DRB Application No.: 06DRB-01399 (P&F)  
Project Name: FAIRGROUND ADDITION  
Agent: Advanced Engineering & Consult.

Project # 1005172  
Phone No.: 899-5570

**DEVELOPMENT REVIEW BOARD – SPEED MEMO**

**CITY OF ALBUQUERQUE  
PLANNING DEPARTMENT  
October 4, 2006  
DRB Comments**

PLAT OF  
 LOT 23-A  
 BLOCK 3  
**FAIRGROUND ADDITION**  
 WITHIN SECTION 24, T.10 N., R.3 E., NMPM  
 CITY OF ALBUQUERQUE,  
 BERNALILLO COUNTY, NEW MEXICO  
 SEPTEMBER 2006

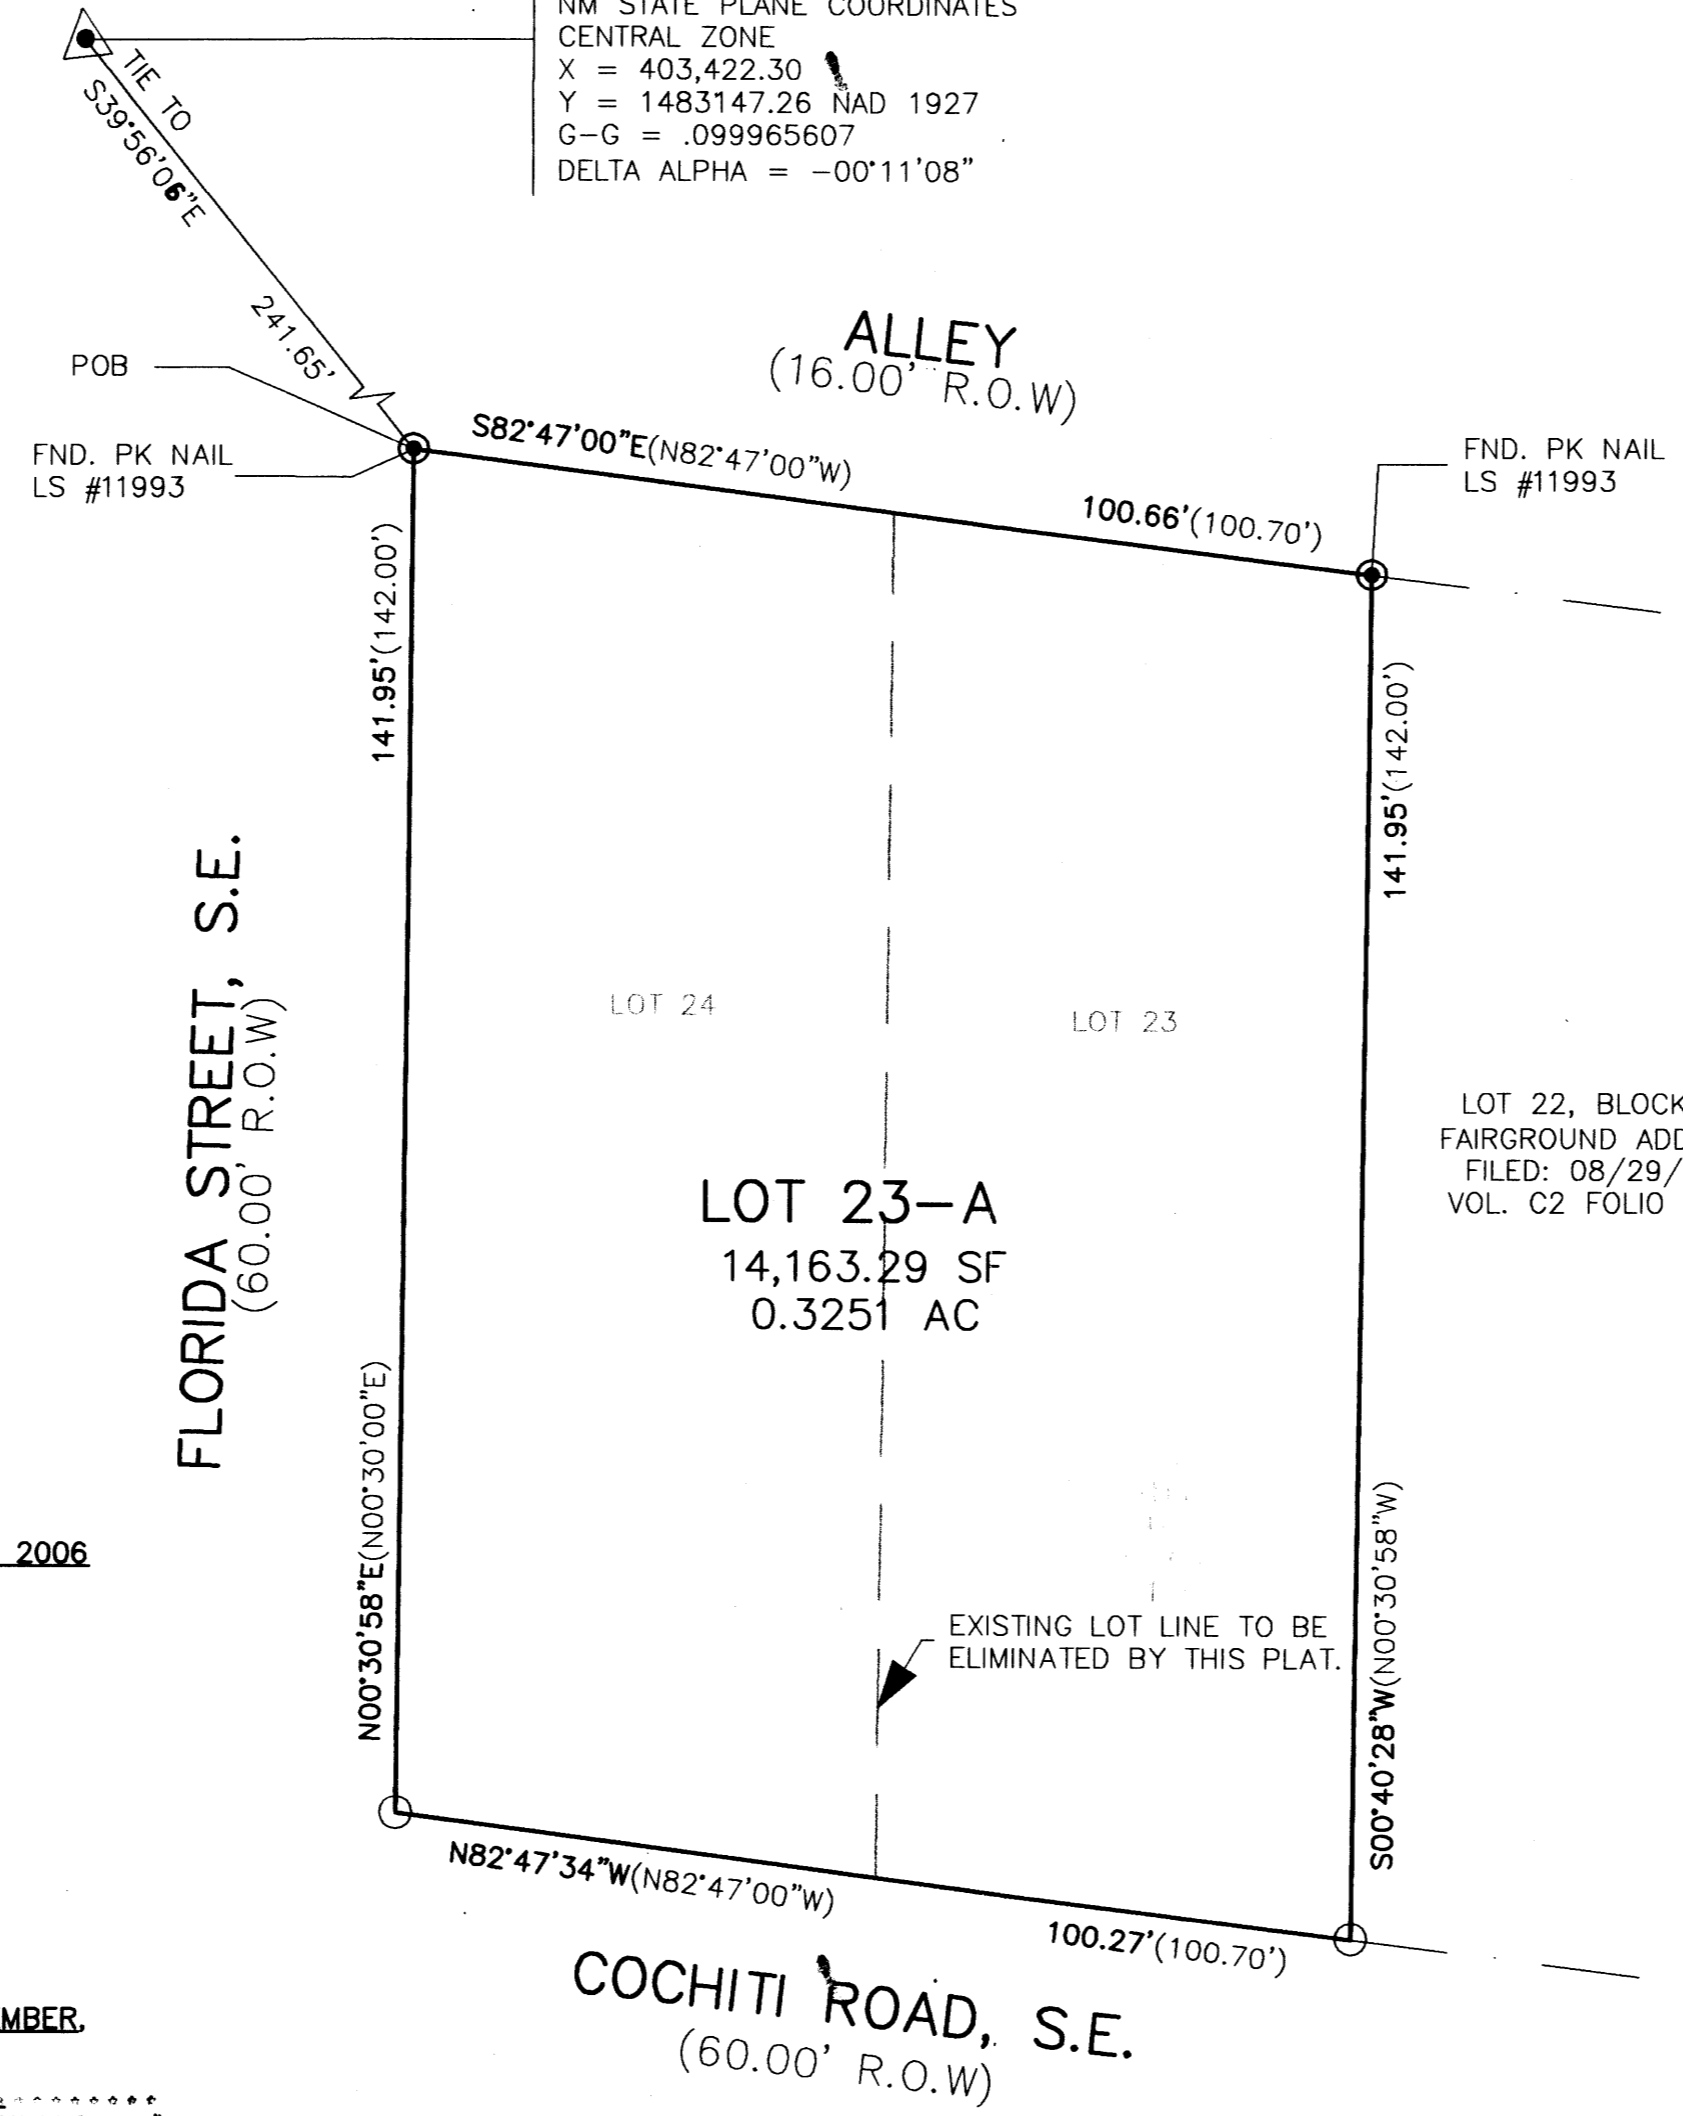
TRANSPORTATION: radius deduction at Florida<sup>NE</sup>; Cochiti NE
